From: Simon Davis
Sent: 17 February 2021 16:45
To: Planning Scanning
Subject: FW: 23018 - Planning Consultation on: Y/148/20/DOC

Condition 12- surface water drainage design

Application No: Y/148/20/DOC

Site Address: Bonhams Field Main Road Yapton BN18 0DX

PERMEABLE CONCRETE BLOCK PAVING
DRIVE CONSTRUCTION DETAIL
Scale 1:20

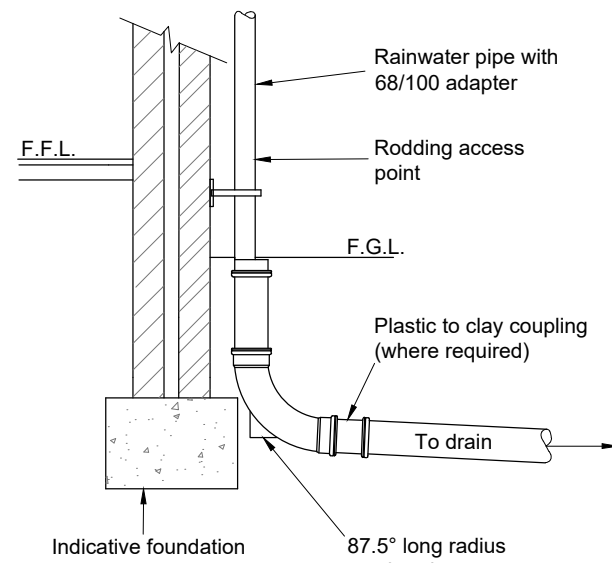
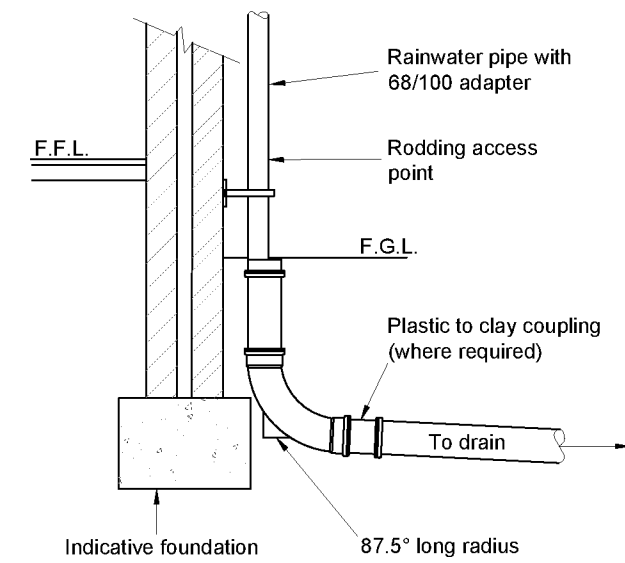
5. I note that in areas G and H you are proposing to locally deepen the sub-base around diffusers. Inlets should be set above the 1 in 10 year plus 40% cc event water level, they certainly should not be set below the base. Please reconsider the design here and check all areas have inlets set above the 1 in 10 year plus 40% climate change water level.

Further to the revisions above we have removed the locally thickening with the diffuser tanks have now been placed just above the formation level in these catchments, which is the highest point the diffuser tank can be set to ensure that minimum pipe falls and cover can be achieved. *There are many areas where incoming connections are set below the 1 in 10 year, let alone 1 in 10 year plus 40% water level. This is not acceptable, please review. There is even one diffuser tank proposed below formation level. I note your comments about minimum falls, however your current proposals do not meet requirements. You may need to take some of the downpipes to more local features in some locations.*

All diffusers are now either at or above formation level as discussed. This has been accepted elsewhere by Arun District Council including on Planning Application A/79/20/DOC approved in July 2020. *Policy requirement for major applications is to have all incoming connections set above the 1 in 10 year plus climate change event water level. The policy requirement comes from both the suds manual and BRE365. The suds manual references that incoming flow to infiltrating structures should be free and unimpeded. BRE365 makes you calculate the storage volume required between the base of the soakaway and the incoming invert for the 10 year event (based on the fact this is the design event in this section of the guidance), specifically "Storage must equal or be greater than inflow minus outflow, defined above, and is the required effective volume available between the base of the soakaway and the invert of the drain discharging to the soakaway." We acknowledge that on sites it will not always be possible to have the invert level above the 1 in 100 year plus climate change event storage, but do require flow to be free and unimpeded for more frequent events. Please demonstrate that your design meets policy requirements.*

CLIENT Seaward Properties Limited	
PROJECT Bonhams Field, Main Road, Yapton	
TITLE Site Layout Proposed Drainage Plan Sheet 1 of 4	
DRAWN M Pacifico	DATE June 2020
ENGINEER S Magowan	CHECKED SRM
PROJECT NO. 23018	
SCALE 1:200 @ A1 / 1:400 @ A3	
1221 A

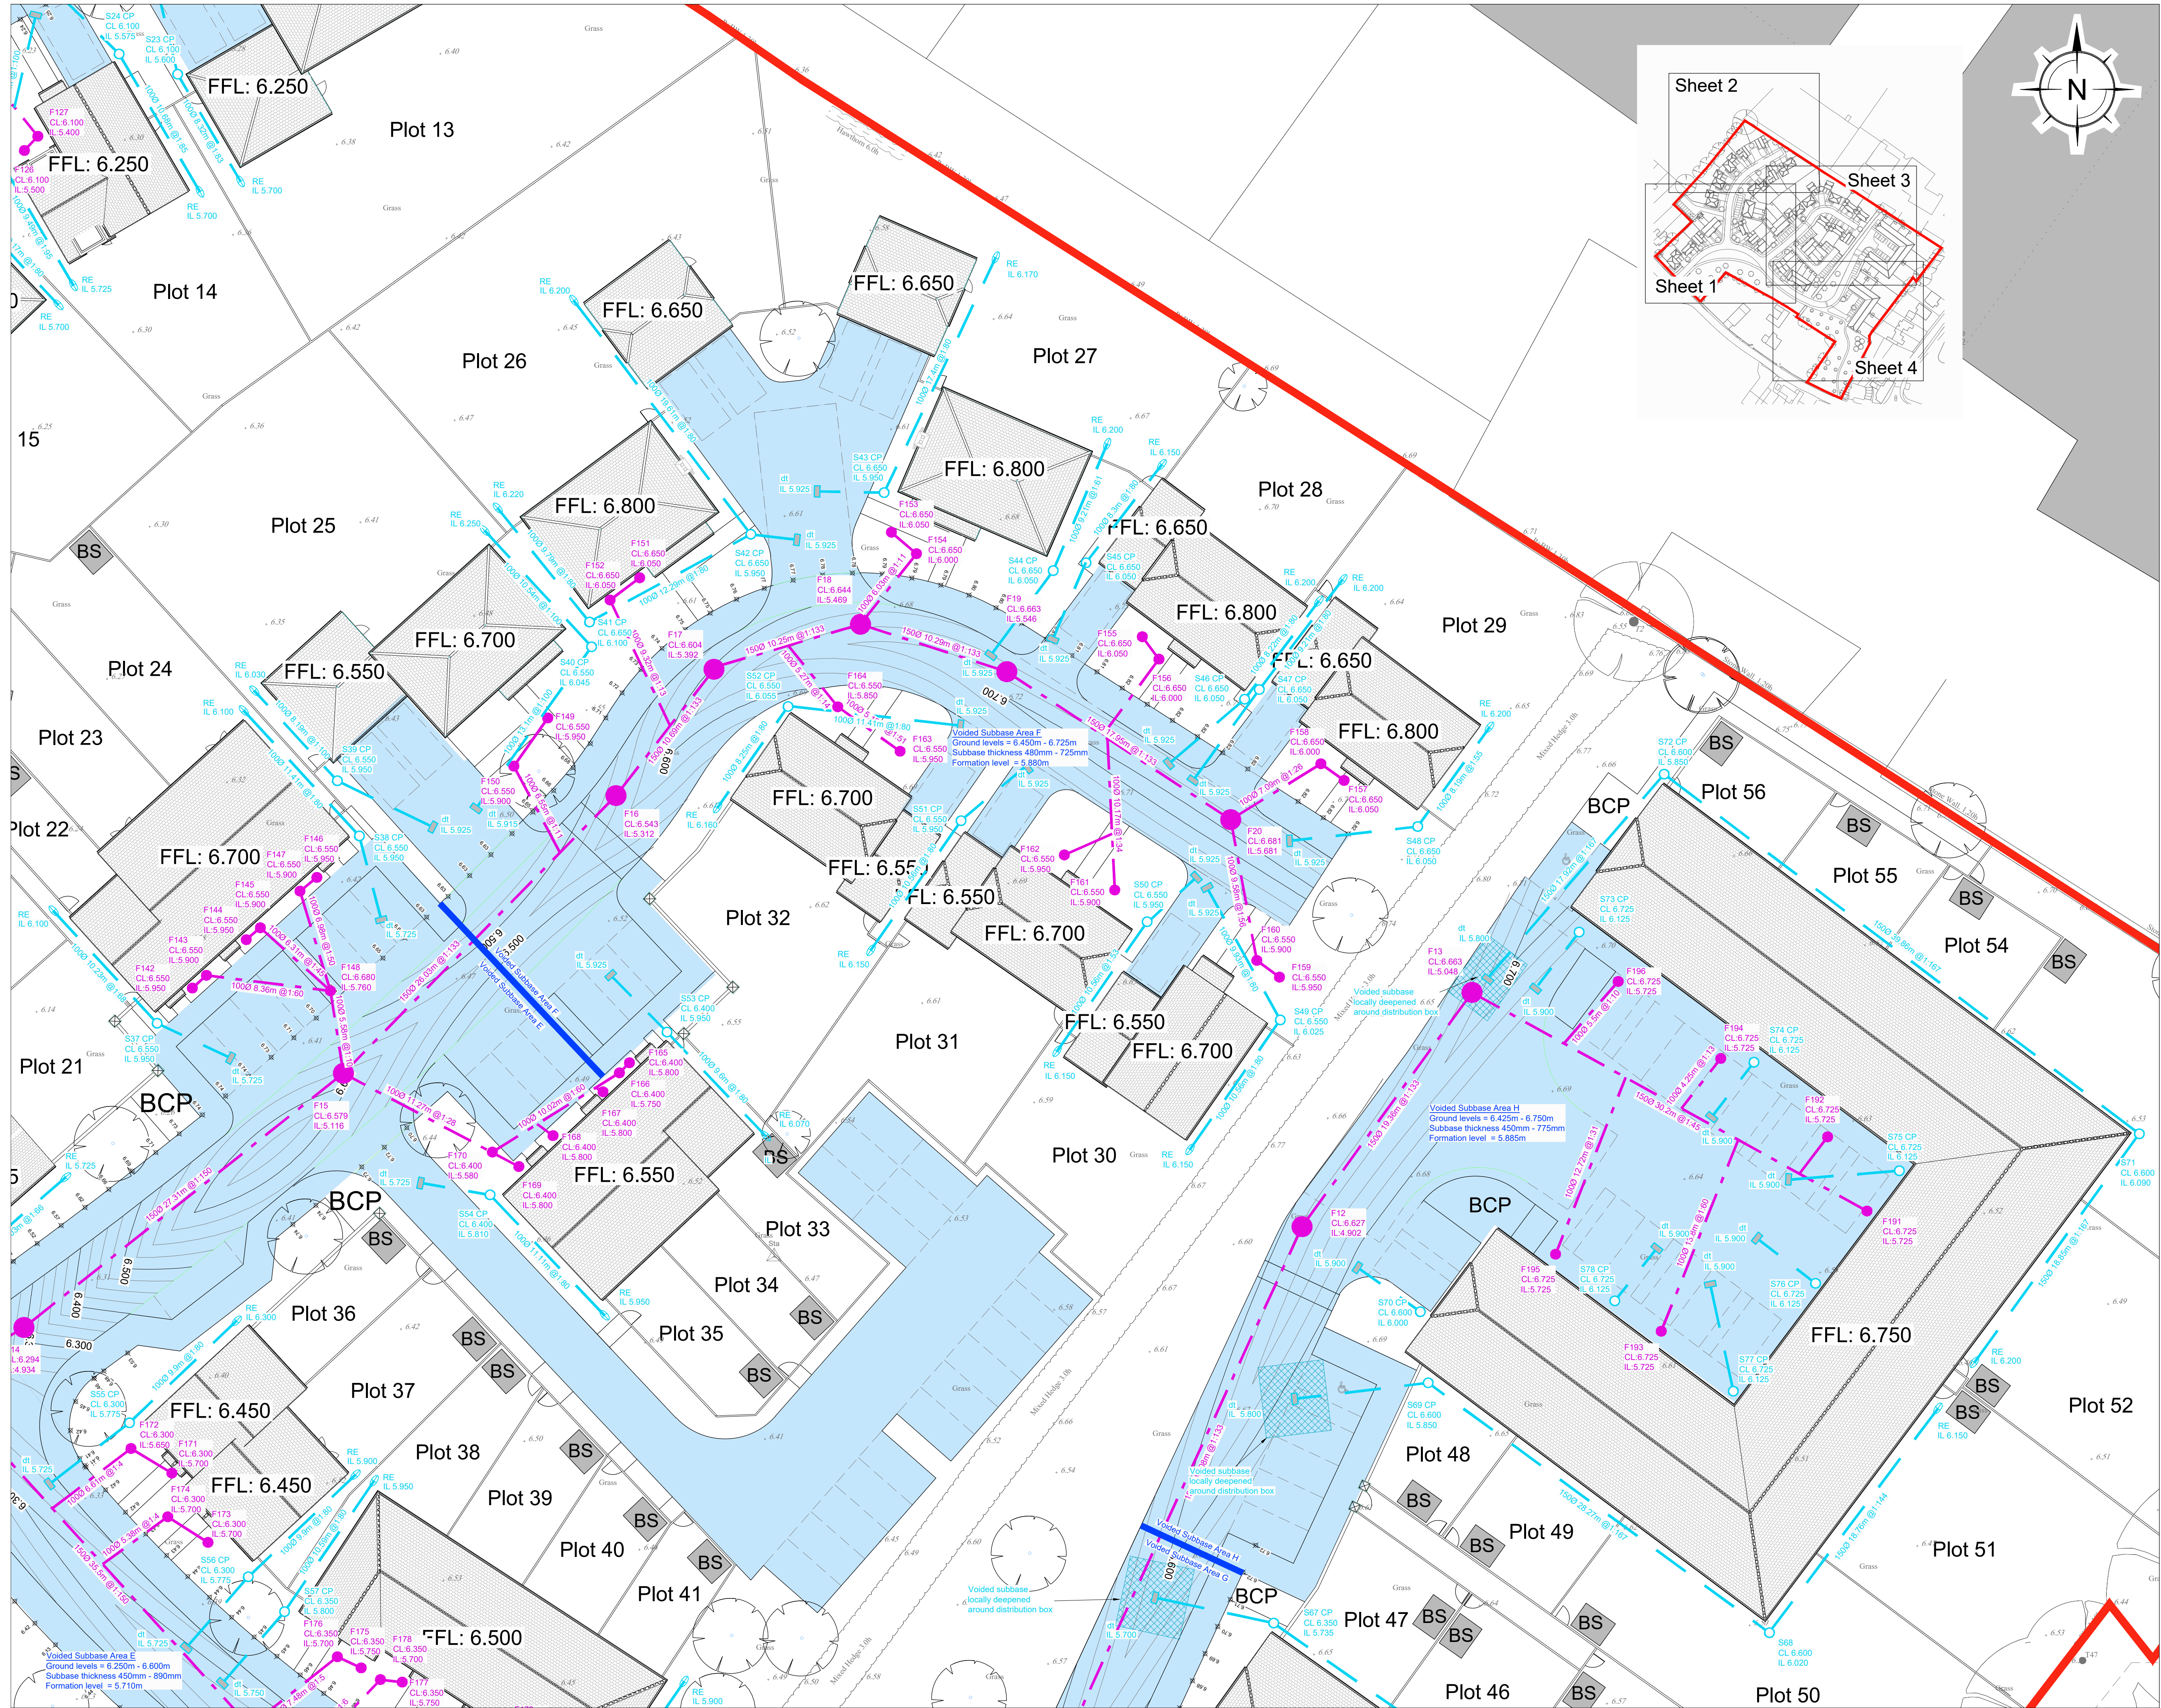
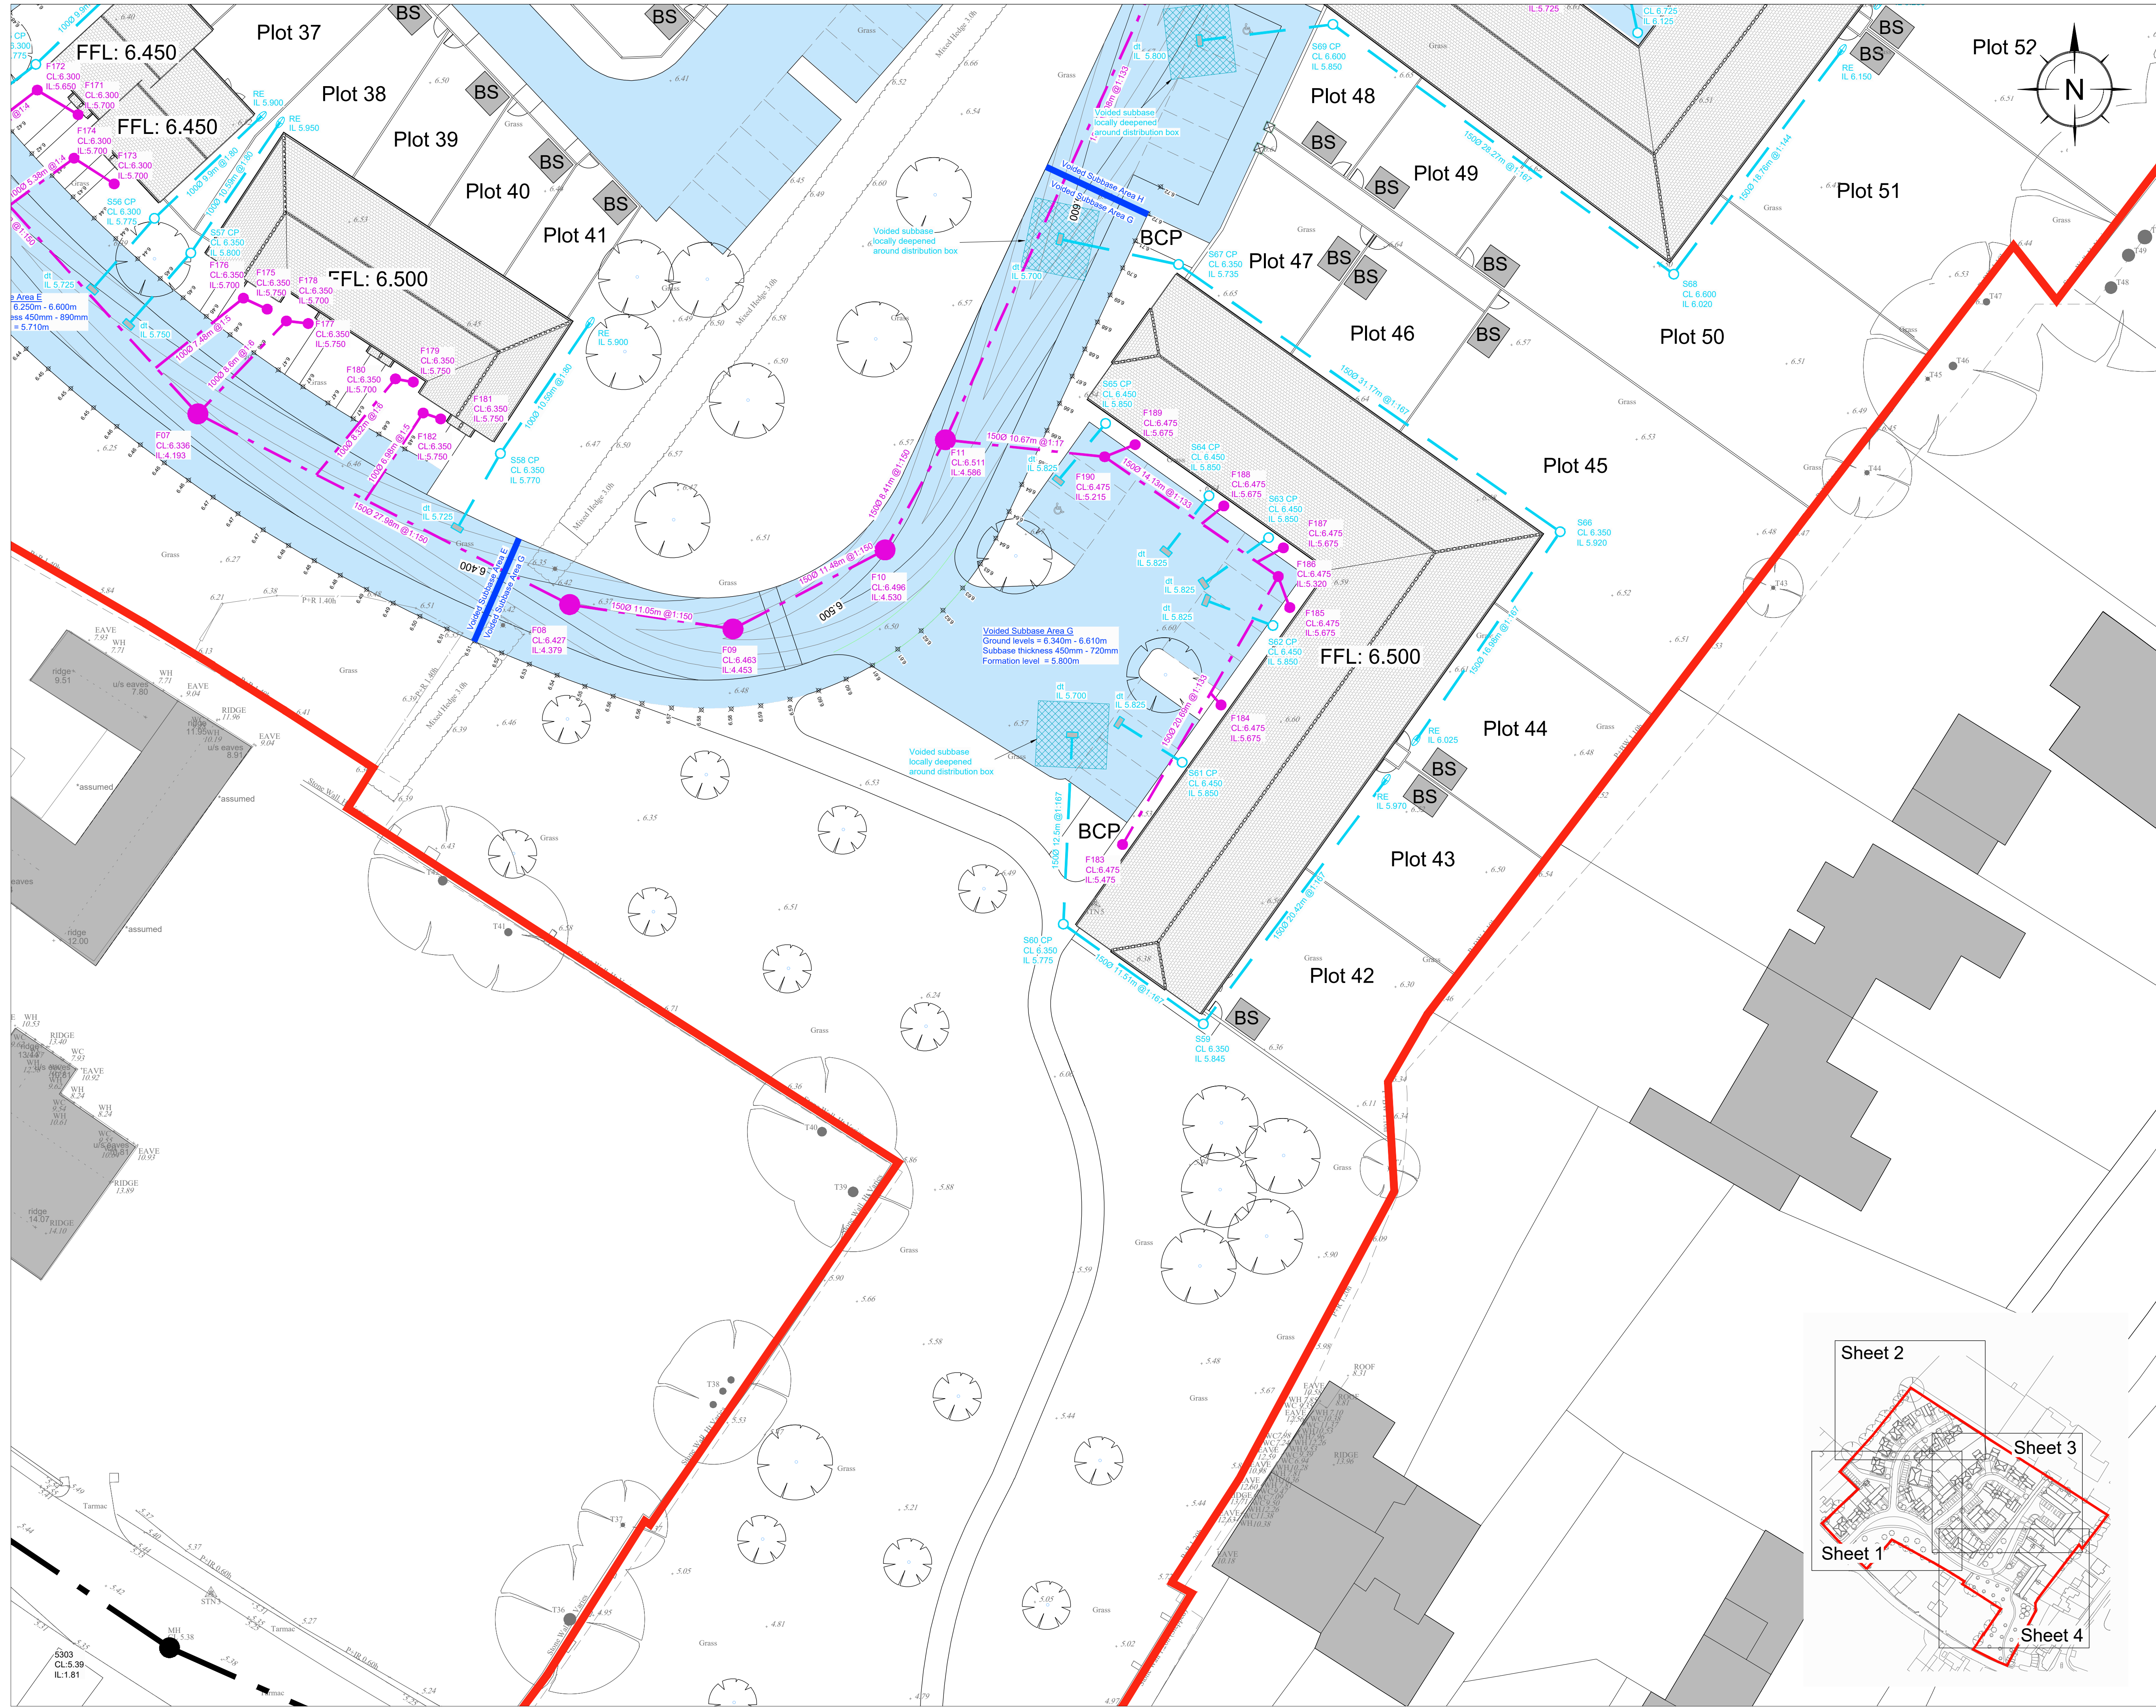
4. A factor of safety of 2 has been used throughout. This is low. We would like to see a factor of safety of 4 applied to catchment areas greater than 1000m². We see this as a substantial compromise upon the table contained within our checklist.

Following our discussions we have updated all calculations to include a Factor of Safety of 4 and updated subbase depth accordingly. This has increased subbase depth by a maximum of 70mm, which is in Catchment H. As discussed the half drain time for the 1 in 100 plus 40% storm event is increased to almost 33 hours which was agreed as acceptable during our recent meeting. The drawings have been updated to reflect this change. *This is not an entirely accurate representation of our discussions. Features must half drain within 24 hours for the 1 in 10 year plus 40% cc event, as detailed this is the absolute minimum requirement and can be applied instead of the 100 year plus cc event when agreed by the local engineer. Please supply half drain times for the 1 in 10 year plus cc event for all features where half drain time exceeds 24 hours for the 1 in 100 year plus cc event.*

Catchment F has a FOS of 2 applied in calculations.

I note that pipe falls of 150 diameter pipes are at 1:167, this is below the gradient required to achieve 1m/s self-cleansing velocity. Please ensure all pipes achieve minimum falls.
